SUBJECT: REZ 2024-059: 2040 Comprehensive Plan Consistency

LOCATION: 5112 Sardis Road (PID: 18701102, 18701101)

DESCRIPTION: Zoning Change Request from **N1-A** to **N2-A(CD)** -- 2.67 acres.

RZ-1.0

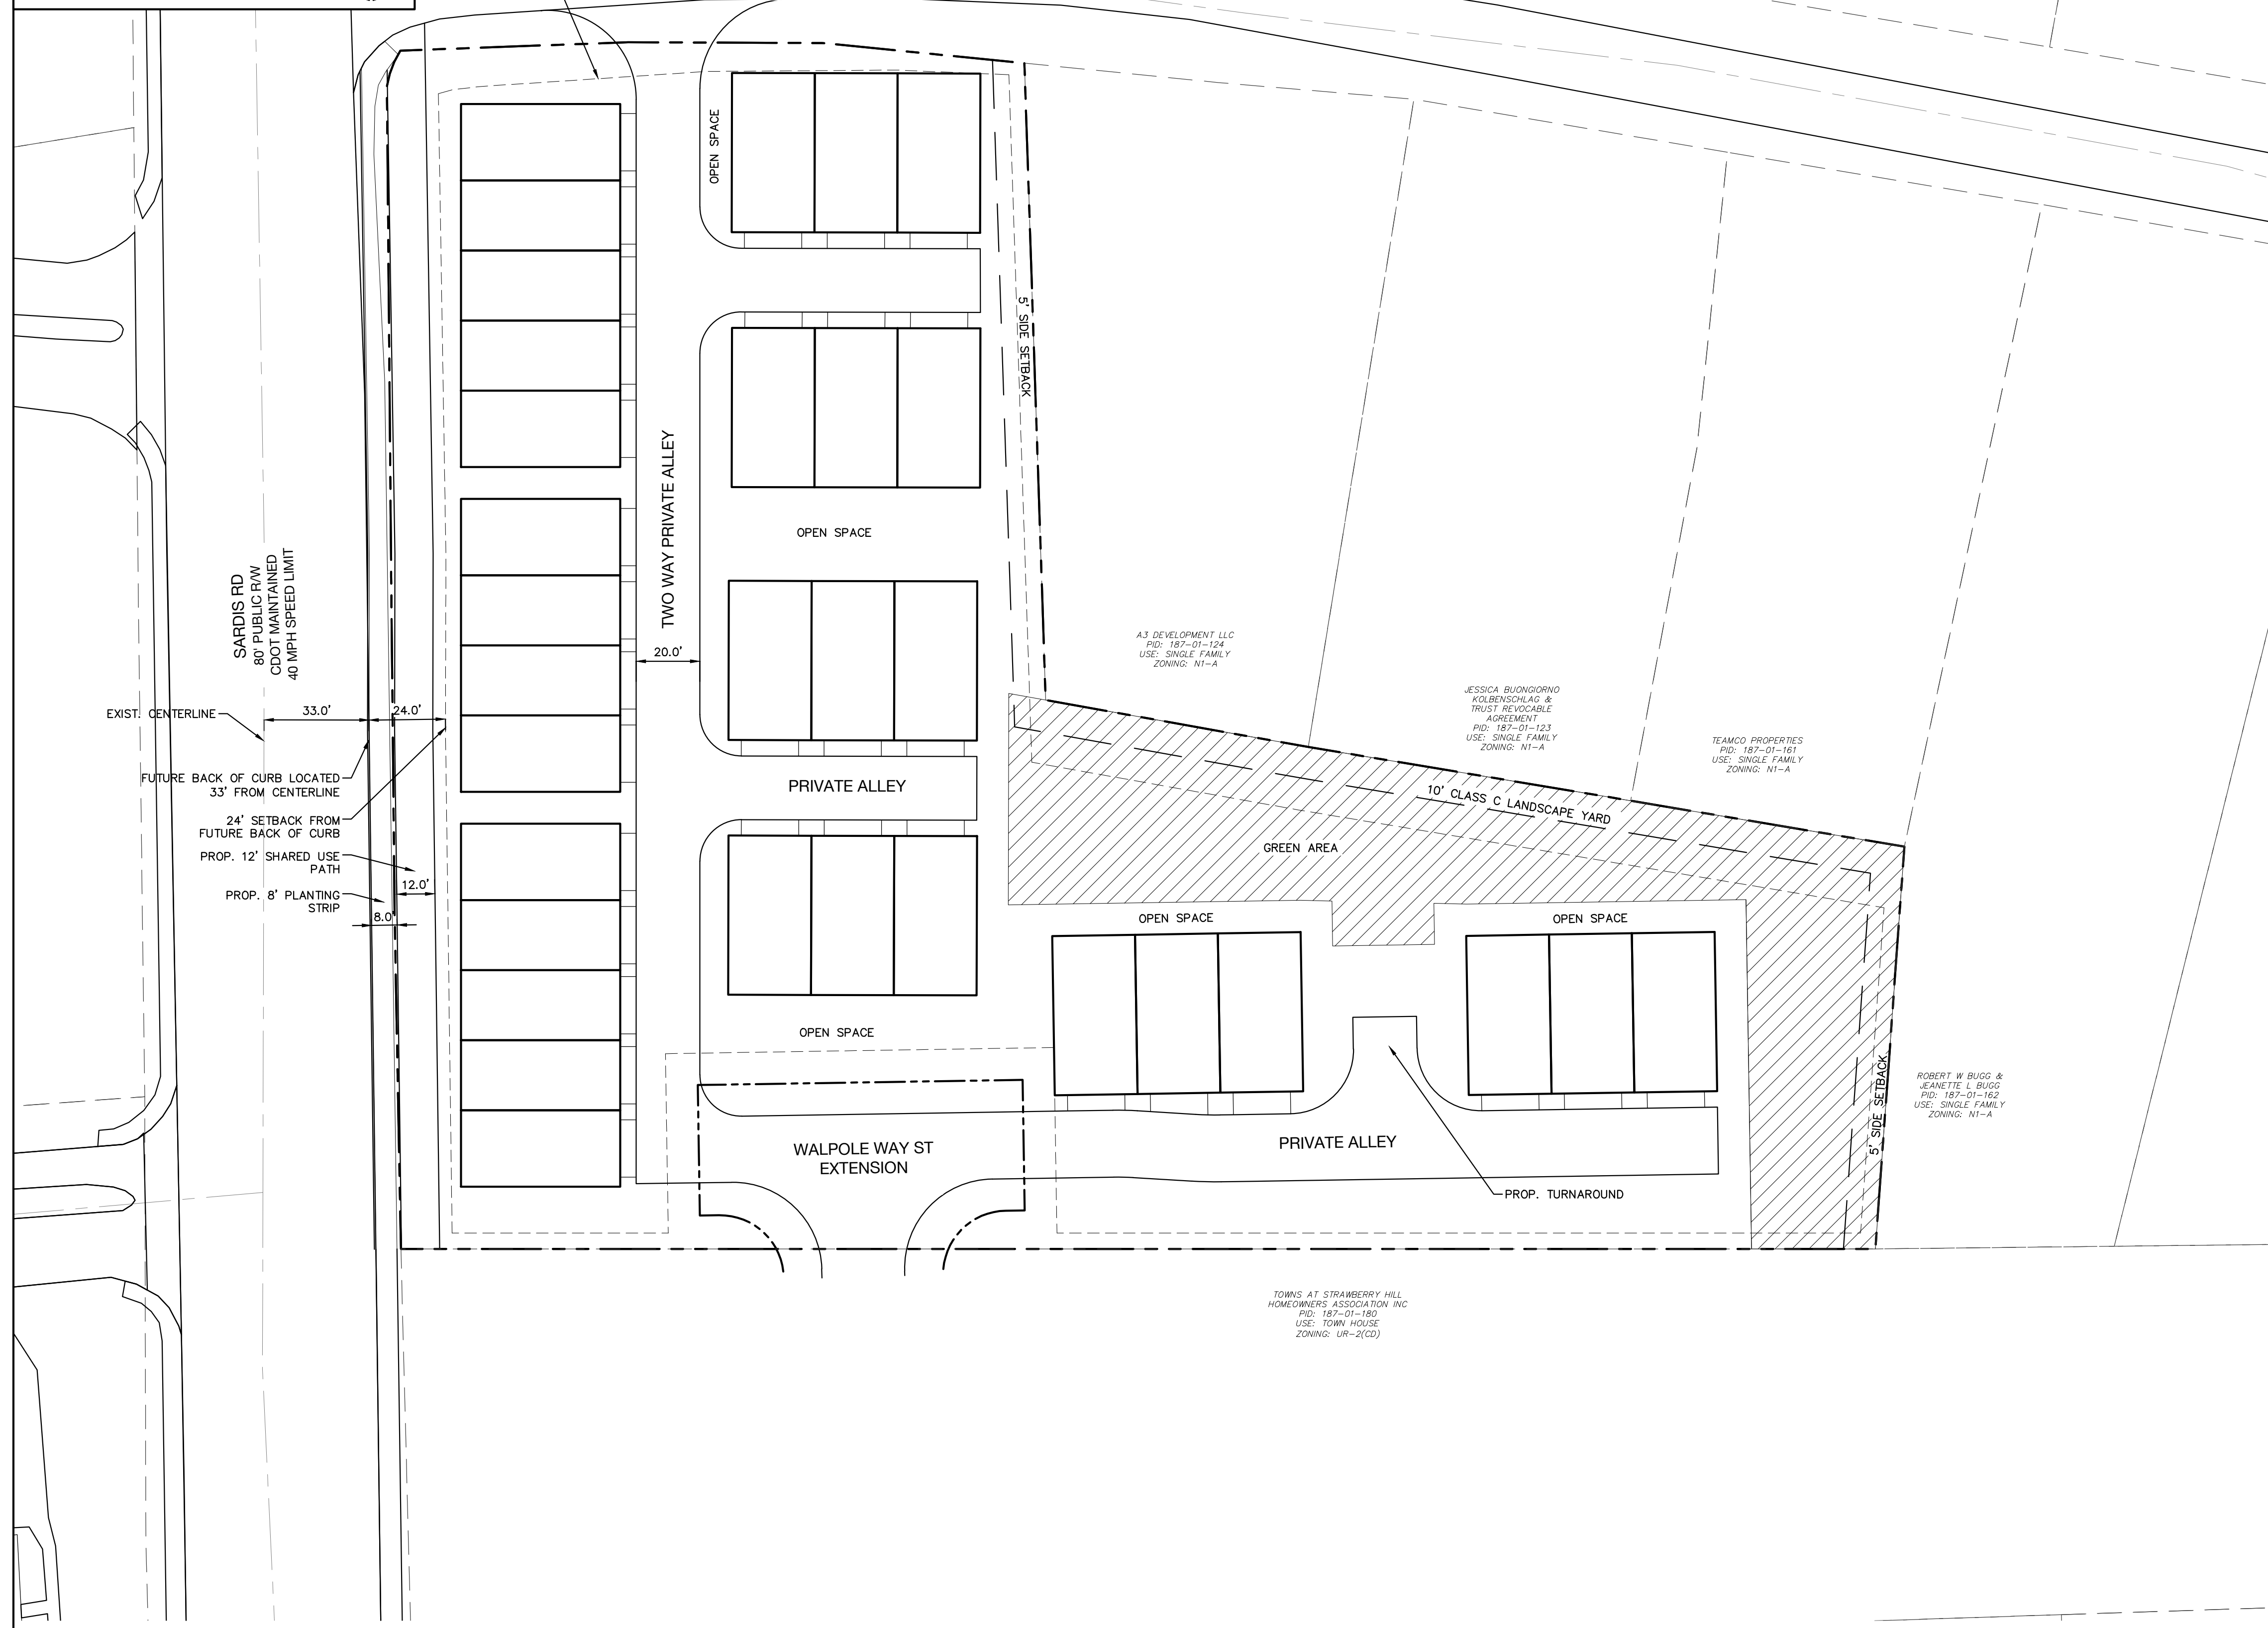
Goal 5: Safe & Equitable Mobility – Charlotte will provide safe and equitable mobility options for all travelers regardless of age, income, ability, race, where they live, or how they choose to travel. An integrated system of transit and tree-shaded bikeways, sidewalks, shared-use paths, and streets will support a sustainable, connected, prosperous, and innovative network that connects all Charlotteans to each other, jobs, housing, amenities, goods, services and the region. **The petition includes a proposed street connection to Walpole Way on the subject property and sidewalks on one side of the alleys. However, the petition does not provide a sidewalk connection from Sardis Rd to the alley sidewalks.**
